From: David O'Connell <DOConnell@tweed.nsw.gov.au>
Sent: Tuesday, 11 November 2014 2:07 PM
To: Robert A Byrne
Cc: Mick Denny
Subject: FW: MP07_0179 MOD Tweed Coast Road Cabarita

The following comments are provided with respect to the conditions to be amended as part of the above referenced Major Project Approval S75W Modification;

project no.	Q1201	scale	1:200	@A0
discipline	AB	sheet no.	0001	D

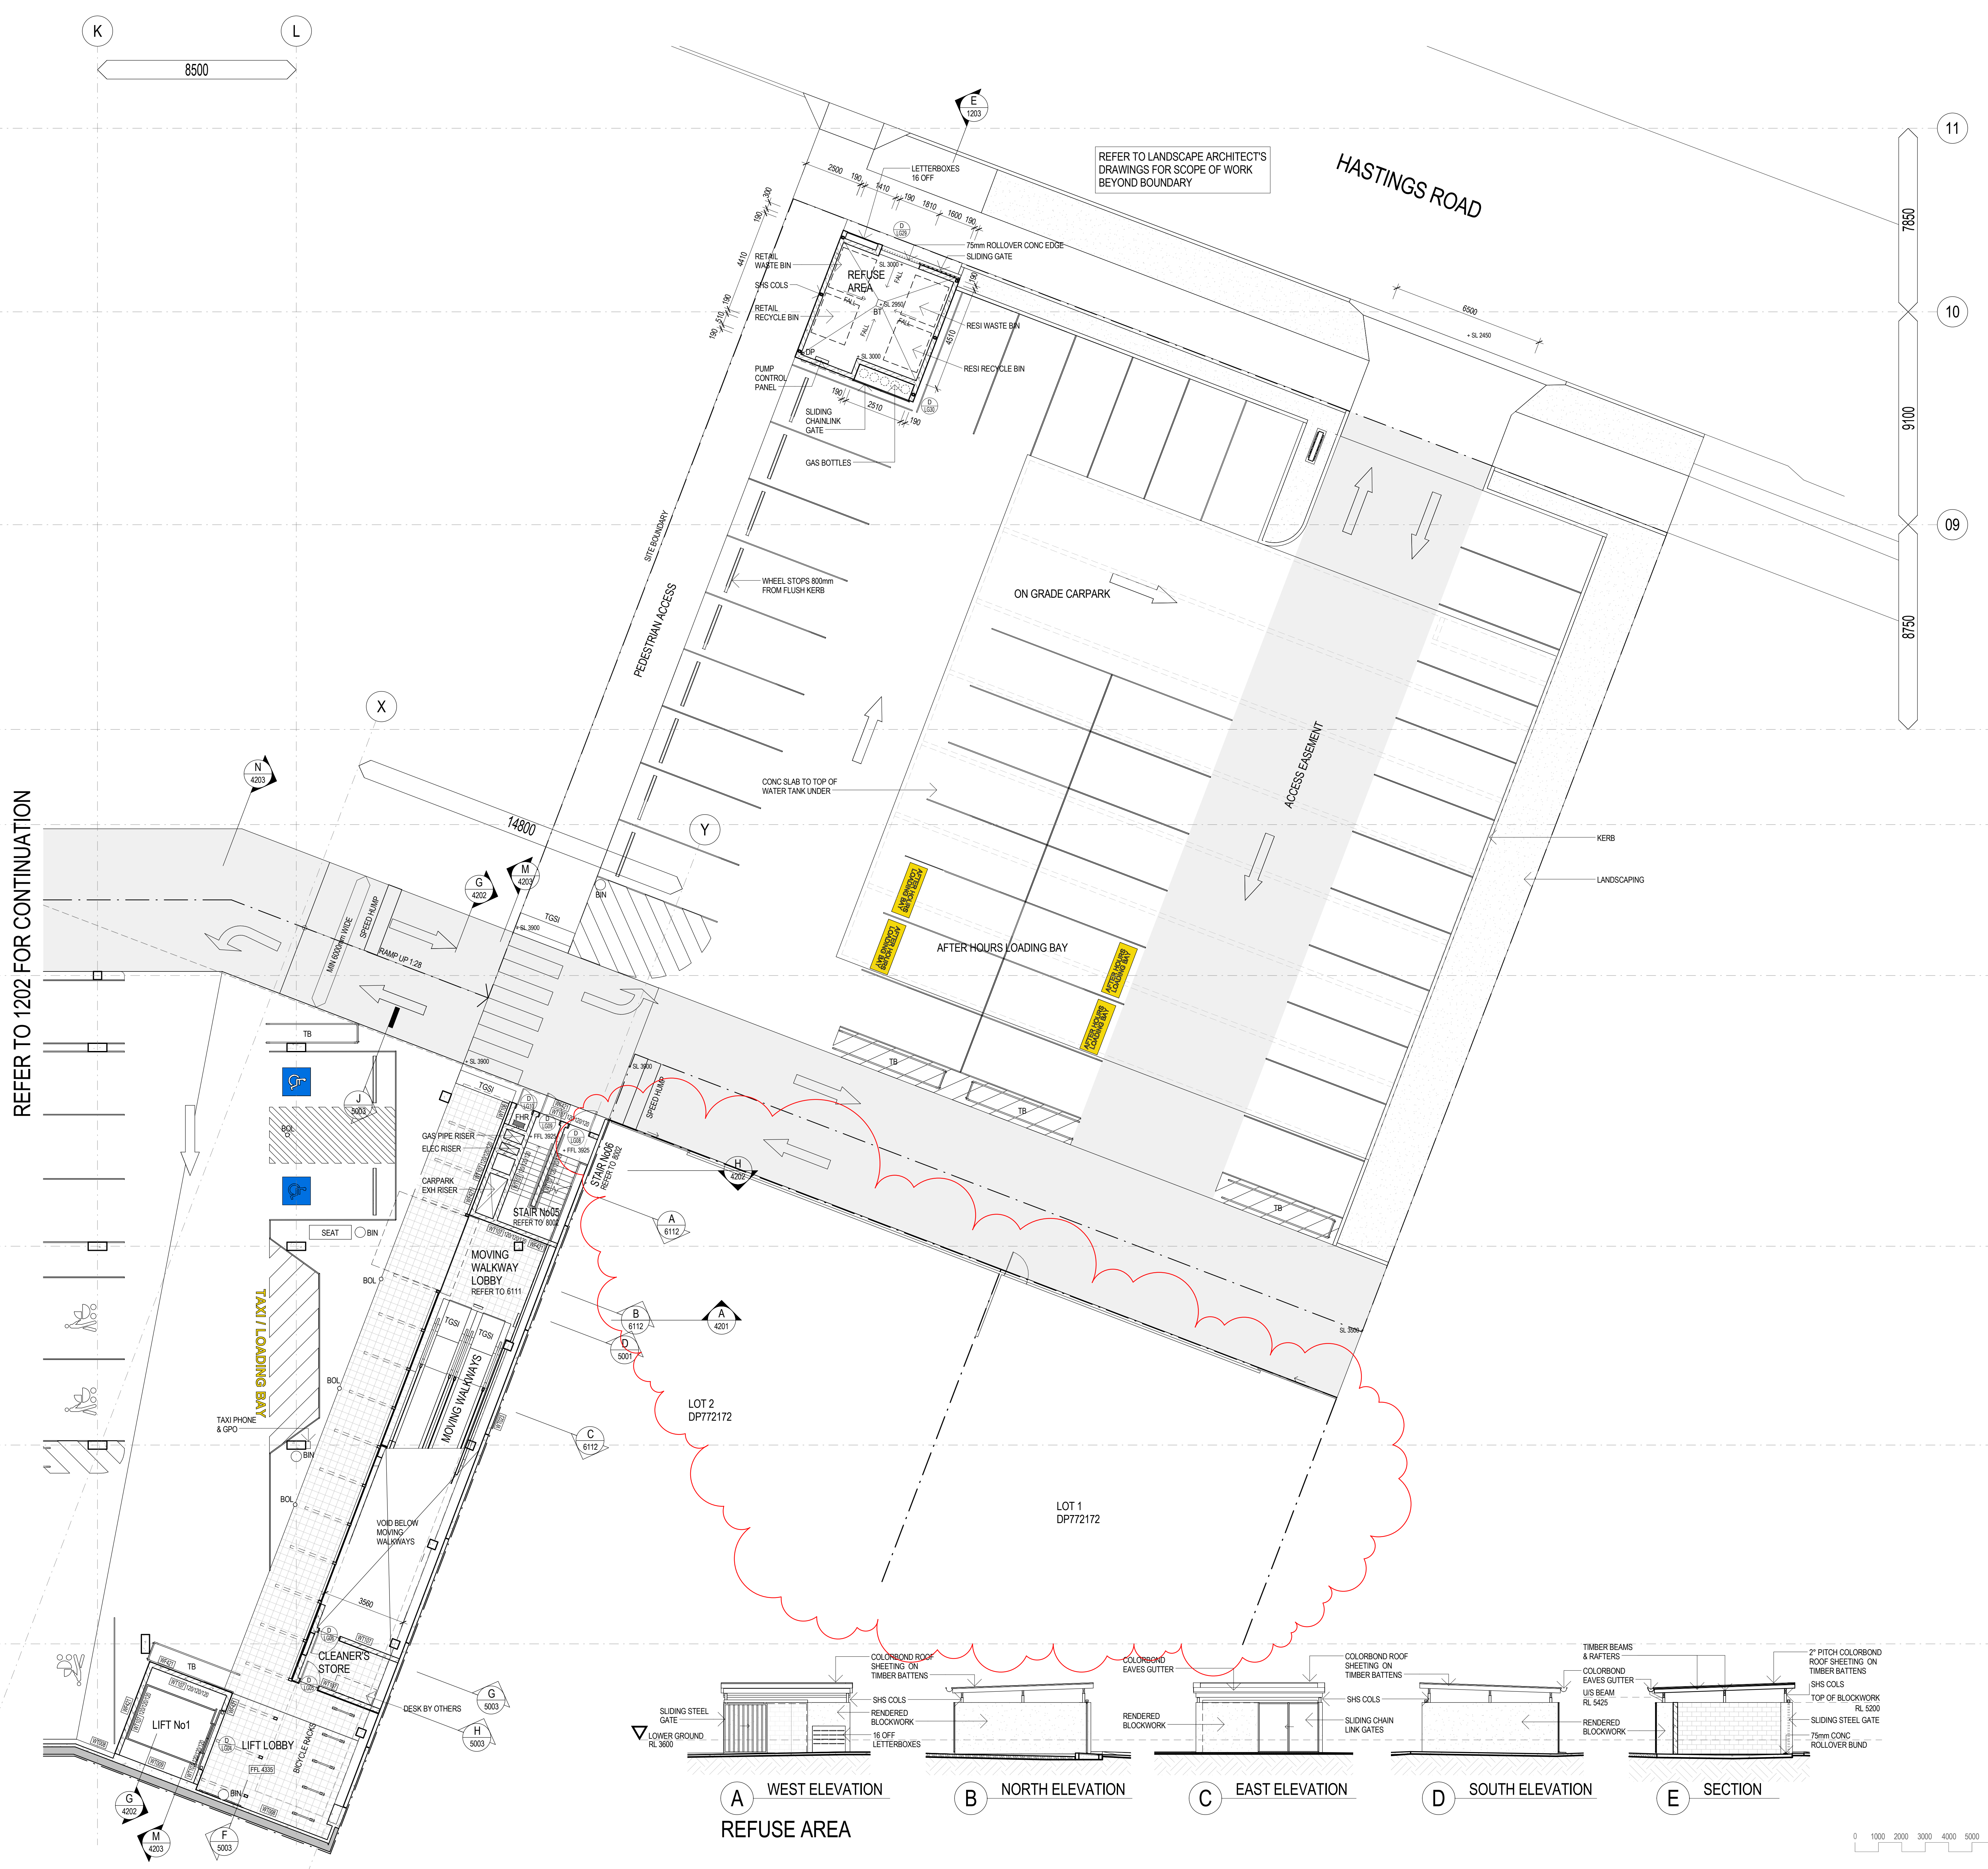
In regards to the laneway within Lots 1 and 2 DP772172, the inclusion of the referenced plans (0001 Rev D Site Plan & 1203 Rev F Lower Ground Level Part B Floor Plan) is supported by Council. This endorsement of these plans does not consider other matters such as the reference of "After Hours Loading Bays" on drawing 1203 Rev F. Such references should be considered by The Department in its assessment of the modification application.
